From: [Holly Duncan](#)
To: [Dusty Pilkington](#)
Subject: RE: BL-17-00021 Teanaway Ridge
Date: Tuesday, December 12, 2017 10:23:17 AM

From: Dusty Pilkington
Sent: Monday, December 04, 2017 9:58 AM
To: Kelly Bacon; Holly Duncan; Josh Hink; Lucas Huck; Mark Cook; Candie Leader; Justin Turnbull; Sara Folk; Karen Hodges; 'jwiseman@snoqualmiepassfirerescue.org'
Subject: BL-17-00021 Teanaway Ridge

Please review this Boundary Line Adjustment (BLA) application, BL-17-00021 Teanaway Ridge, and submit comments for the decision. Control Click on the hyperlinks below. Comment period for this application ends on **12/19/2017**.

PRELIMINARY BOUNDARY LINE ADJUSTMENT EXHIBIT		
PREPARED FOR UNIONVILLE RANCH, LLC A PORTION OF SECTIONS 5 AND 6, TOWNSHIP 19 NORTH, RANGE 17 EAST, W.M.		
KITTITAS COUNTY	WASHINGTON	
DWN BY DLP/GW	DATE 11/2017	JOB NO. 141361
CHKD BY GW	SCALE 1" = 200"	SHEET 1 OF 1

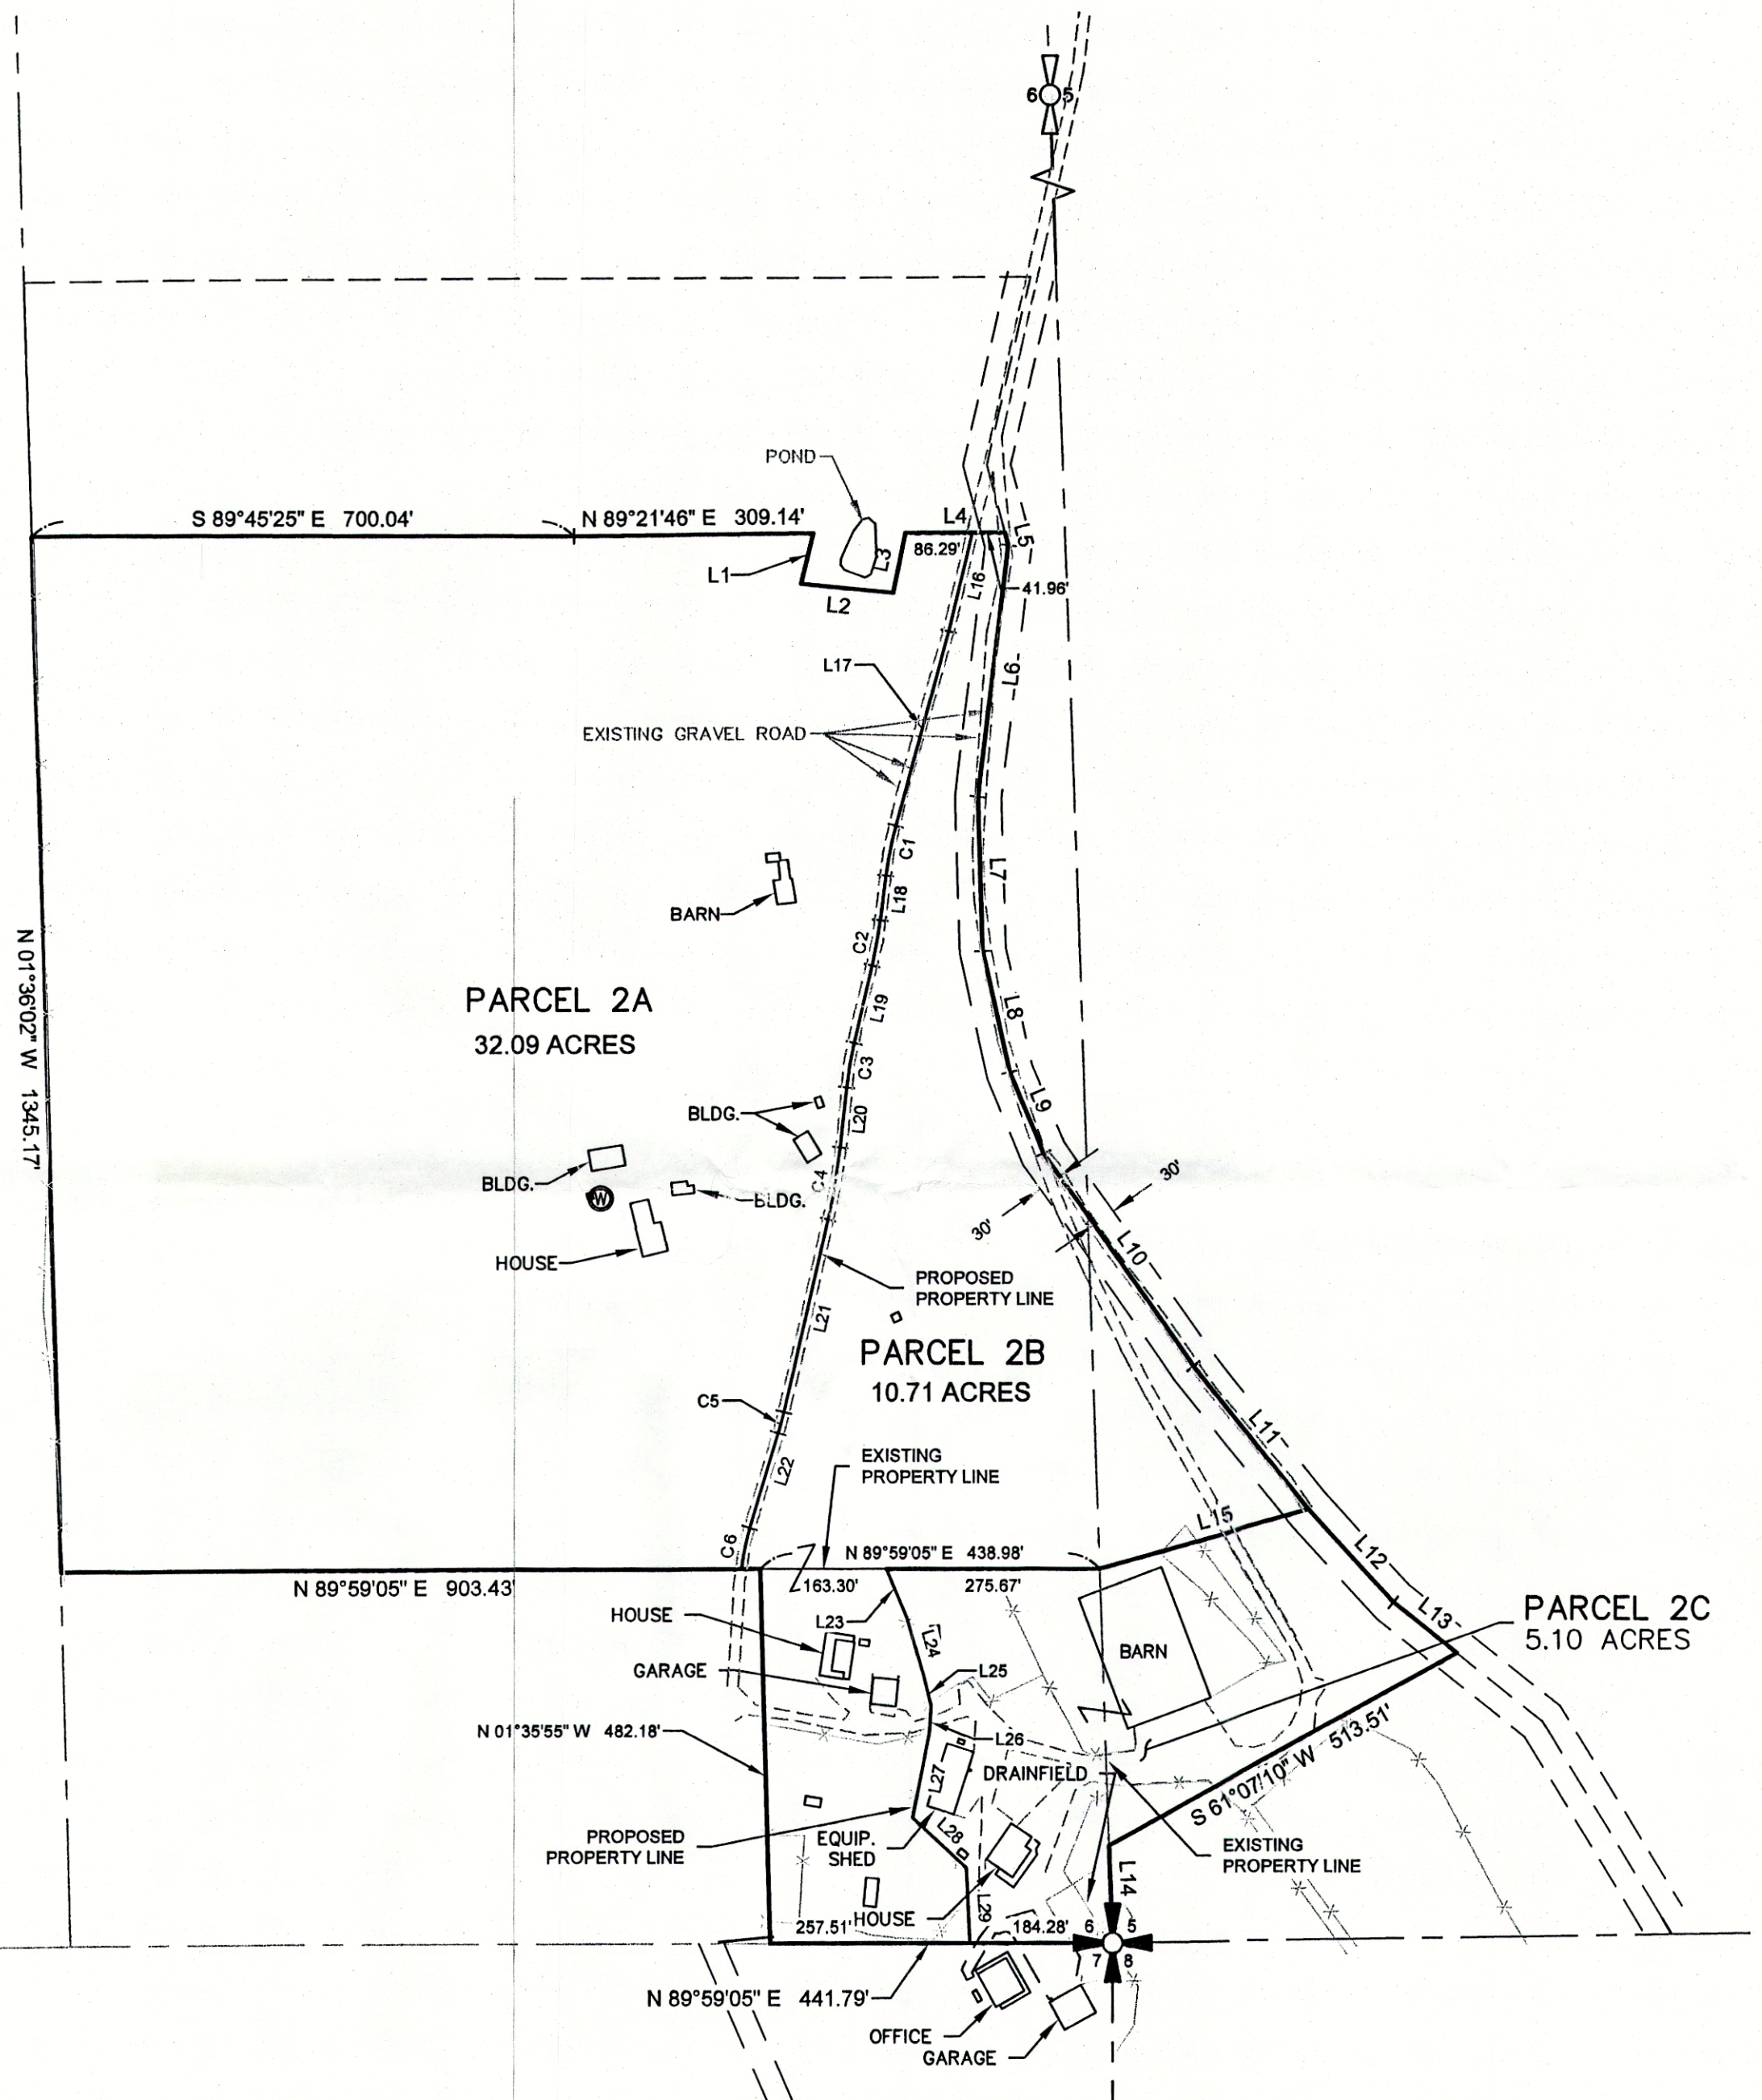
1. There is an existing wellhead near the proposed property line between parcels 2B and 2C that is not shown in the Encompass drawing. According to the records I have, the well head not shown looks like it is right next to the proposed property line which is following a fence line. I will need this existing wellhead included in a drawing. The proposed property line has to be at least 50 feet from the existing well.
2. I also need to see the location of the existing drainfield for the house on the proposed parcel 2B. It is also not shown.
